Technical Response to Tree Preservation Order and Objections from Arboricultural Officer, Land North of Water Lane

Tree Constraints Plan

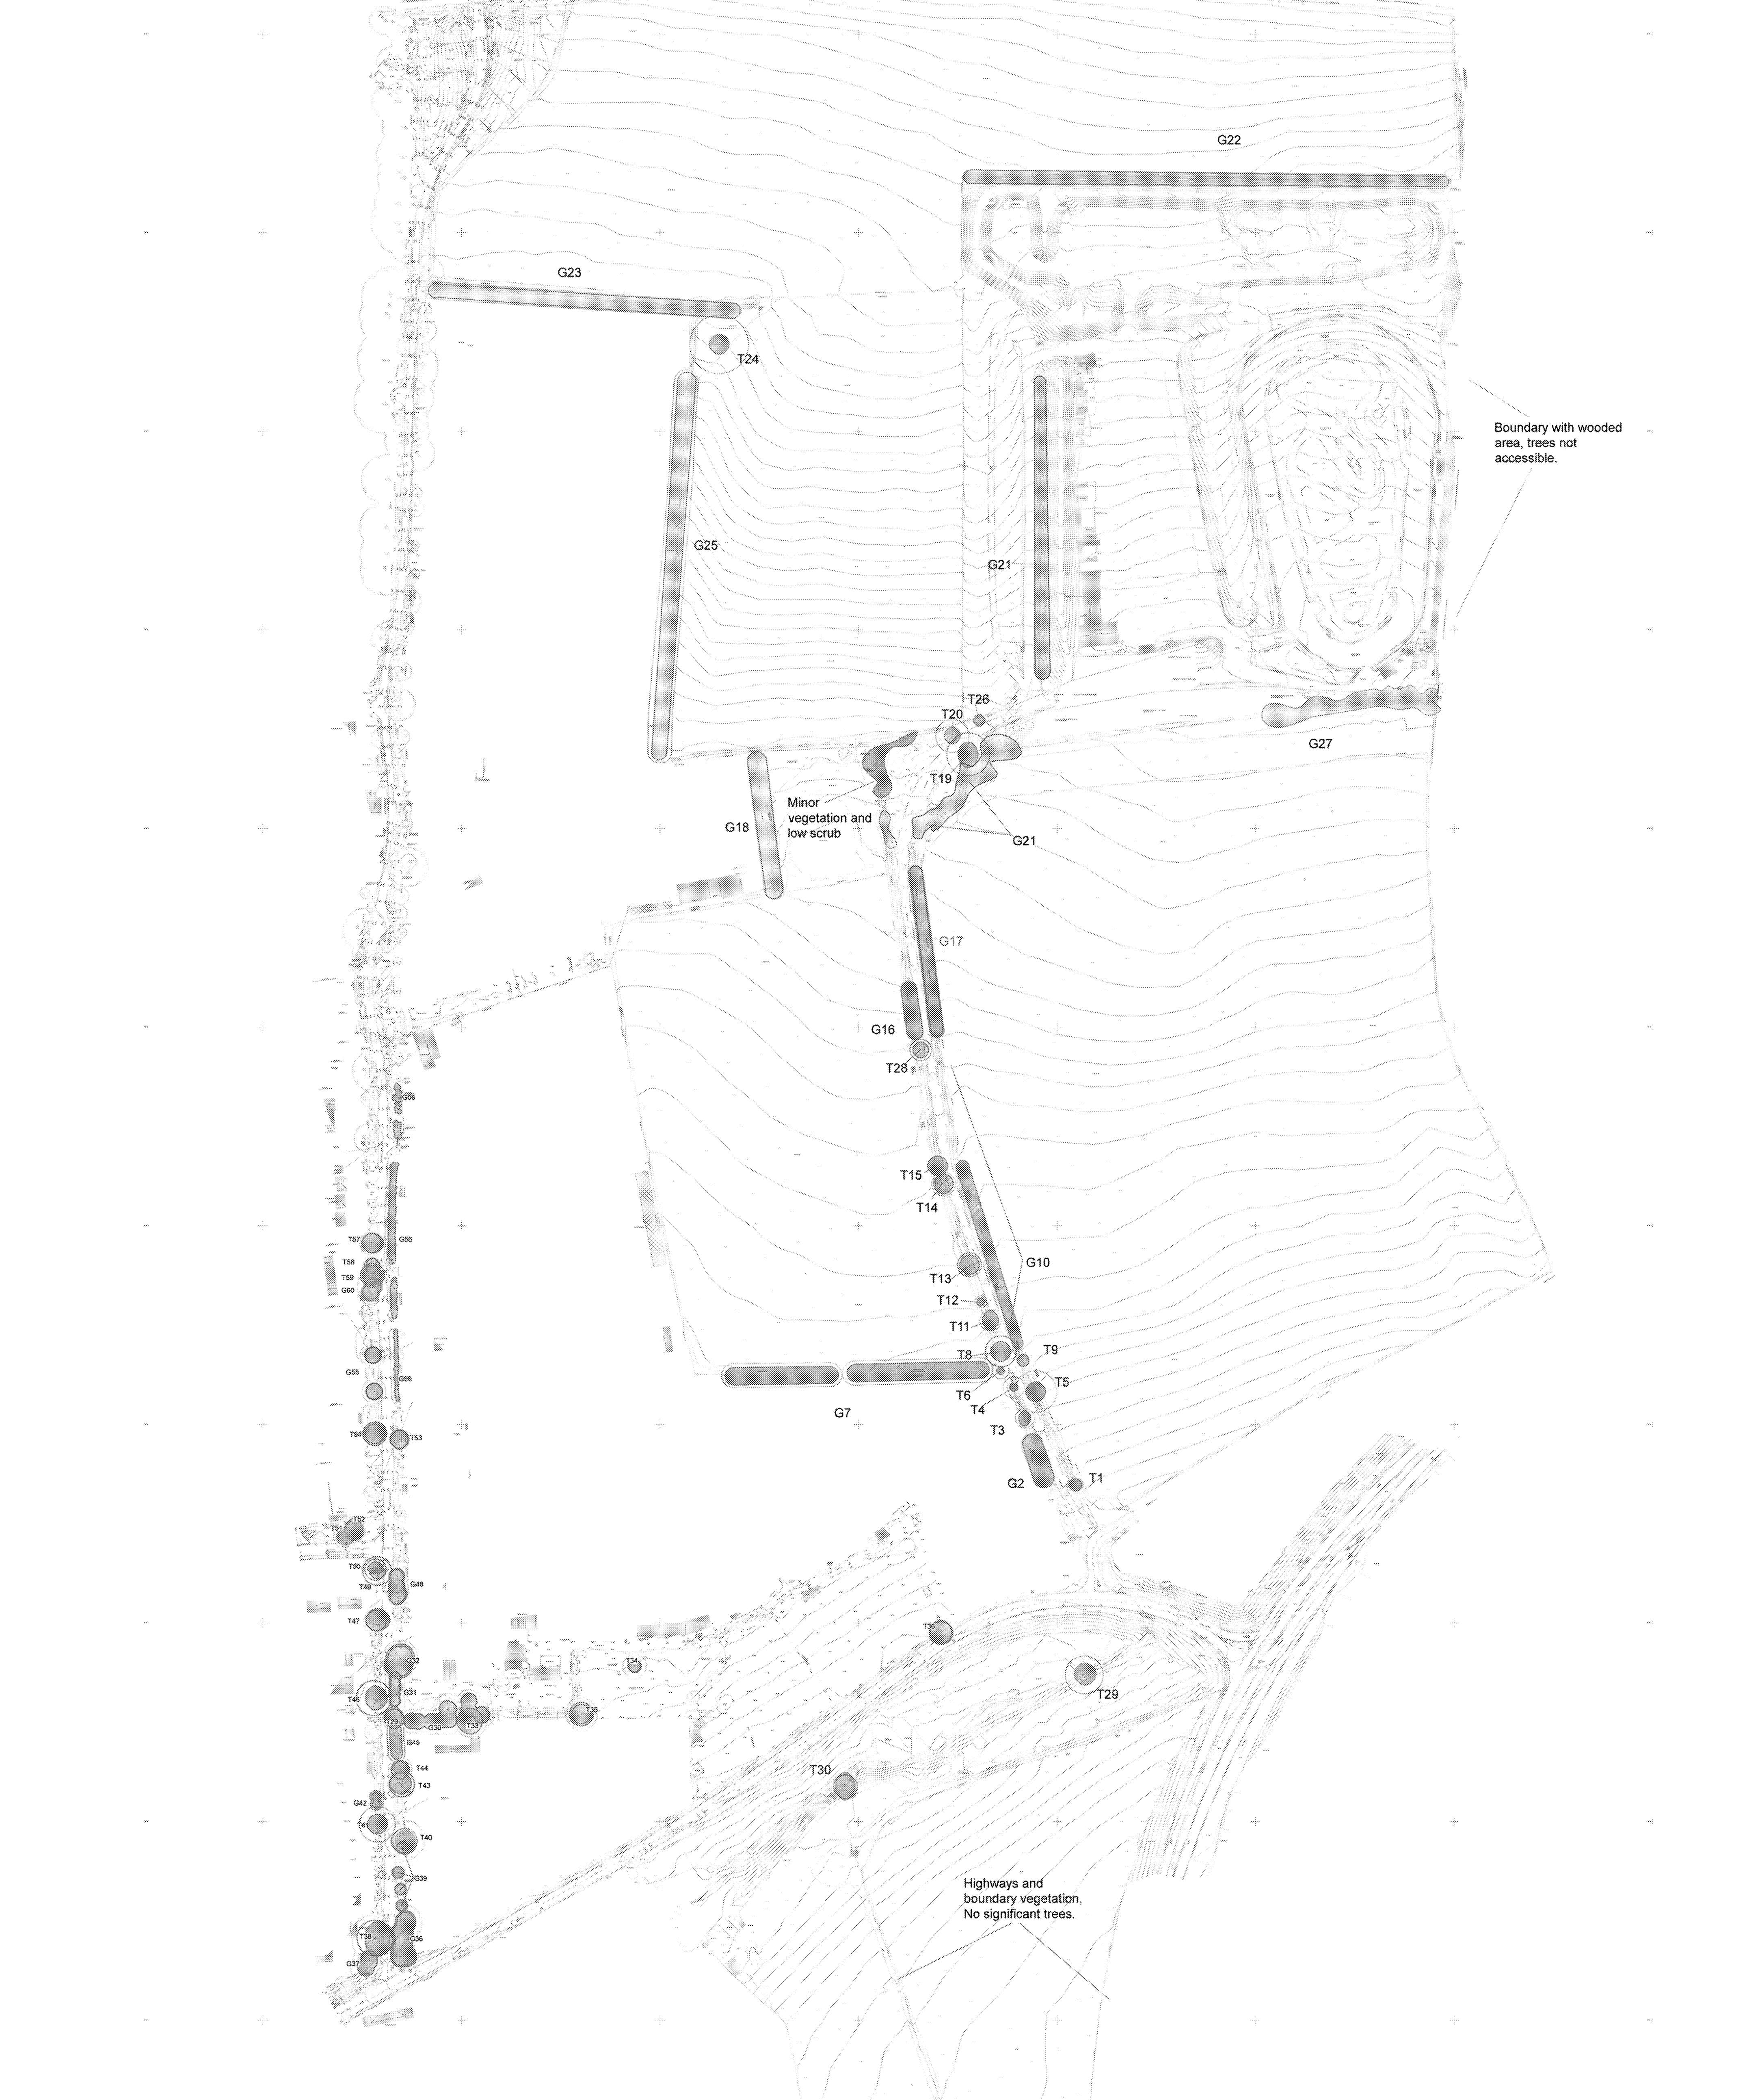
Altering the southern site access is not possible without removal of other trees and tree groups which at present provide natural screening of the proposed layout from the southern boundary. The below image demonstrates this more clearly, the red box highlight the screening vegetation:

The objection to T24 being included in a proposed properties rear garden is unfounded as no physical boundaries are shown. This tree can be part of the landscape buffer rather than assigned to any one property.

The ancient woodland that comprises Groom's Copse has been given a 15 metre buffer zone from the development as per Natural England's standing advice. The 15 metres was measured from the boundary shown on Defra's MAGIC map interactive website, which is the defined method as set out in guidance. Measurement from the crown edge is not a recognised method of setting the 15 metre buffer.

The existing road will be upgraded and already exists meaning little change to the status quo and less notable impact on the landscape. The trees that require removal are at a pinch point in the site and some would have to be removed even if the design was altered in some way. The trees are also in internal parts of the site and can only be viewed in full from the east, where woodland at Grooms Copse excludes views into the site from the wider landscape. Tree loss would be mitigated by extensive planting

and the number of trees lost would be negated by a much larger net tree gain. As indicated in the opening paragraph the AMS would address sympathetic construction techniques and protective measures where construction occurred in proximity to trees.
